20 July 2012

RE: 104 Fessenden St. Interior Remodel  
Revisions since Permit Submittal

This letter is to acknowledge two slight revisions that have been made at the site since the commencement of work.

2 COLUMNS 3 & 4
SCALE: 1/2" = 1'-0"

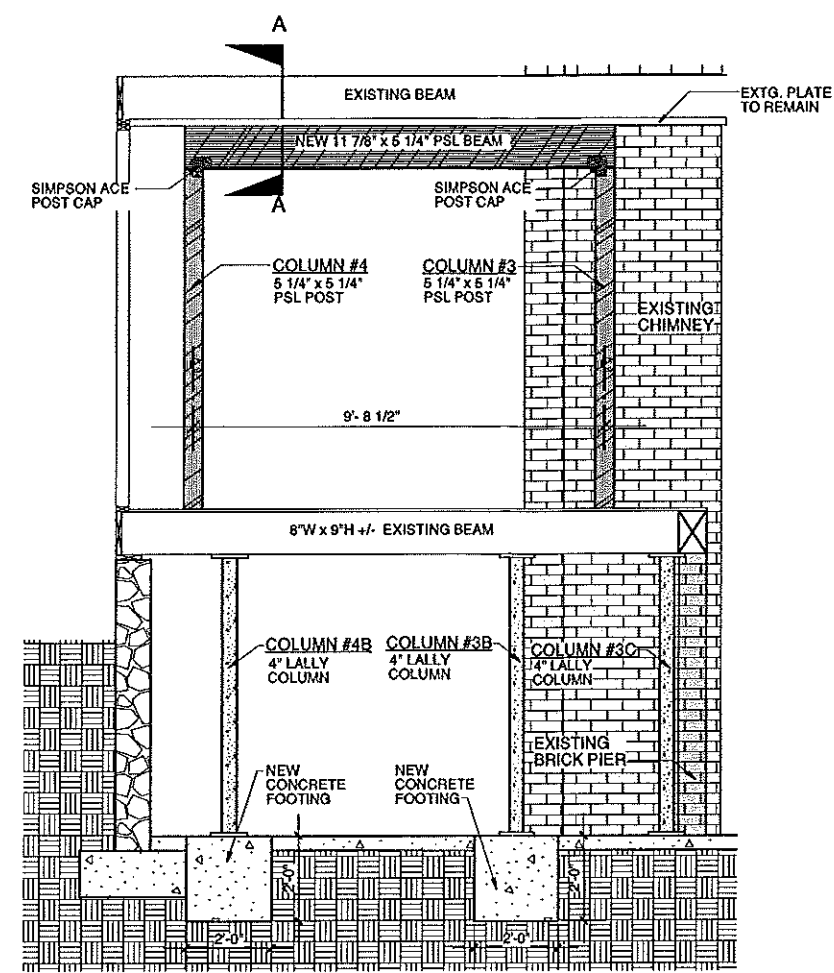
First, demolition phase revealed that a wall previously thought to be a bearing wall was found to not be bearing (structural). Therefore, no PSL beam, posts, lally columns or footings will be required in that location. This appears in Detail 2 / Dwg.A4.1 of my drawings.

1 COLUMNS 1 & 2
SCALE: 1/2" = 1'-0"

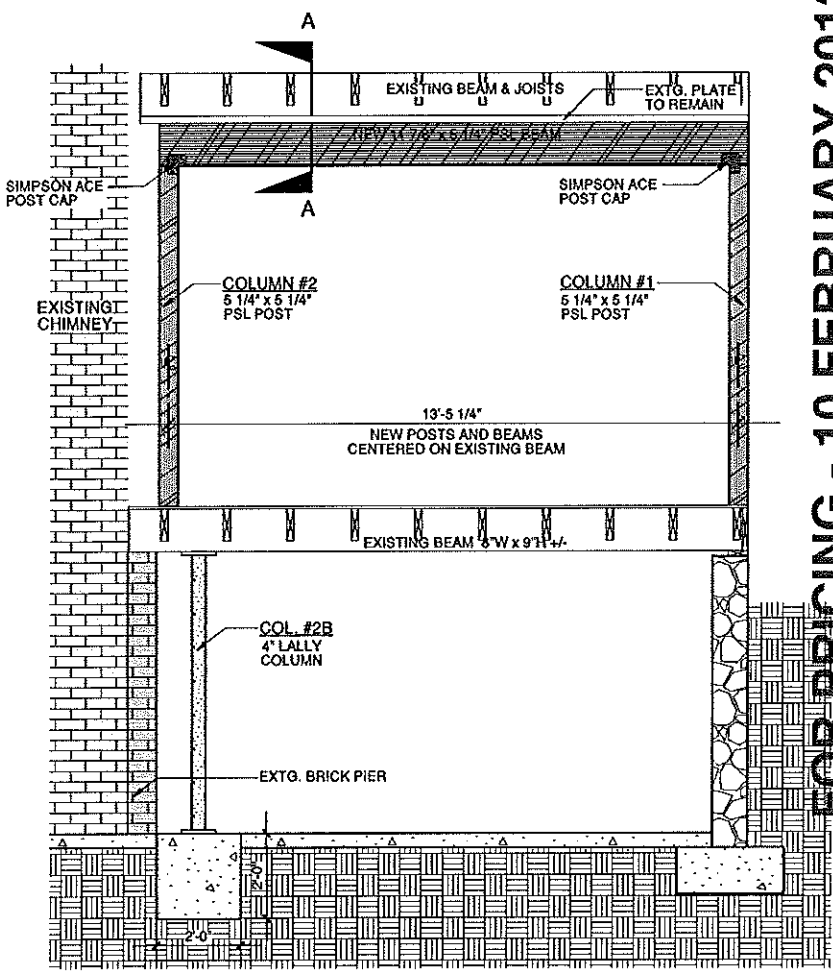
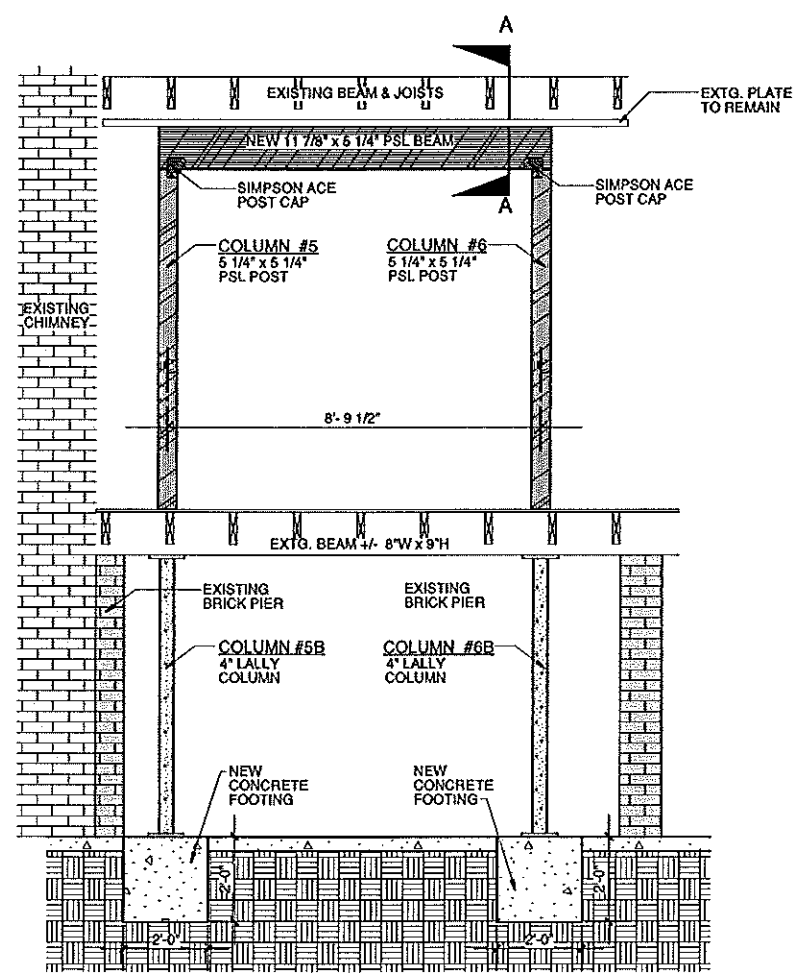
Second, Details 1 and 3/ Dwg.A4.1 note a Simpson ACE Post Cap at each New PSL beam to New PSL post connection. These caps were found to be unnecessary as the beams and columns are locked into place by other framing.
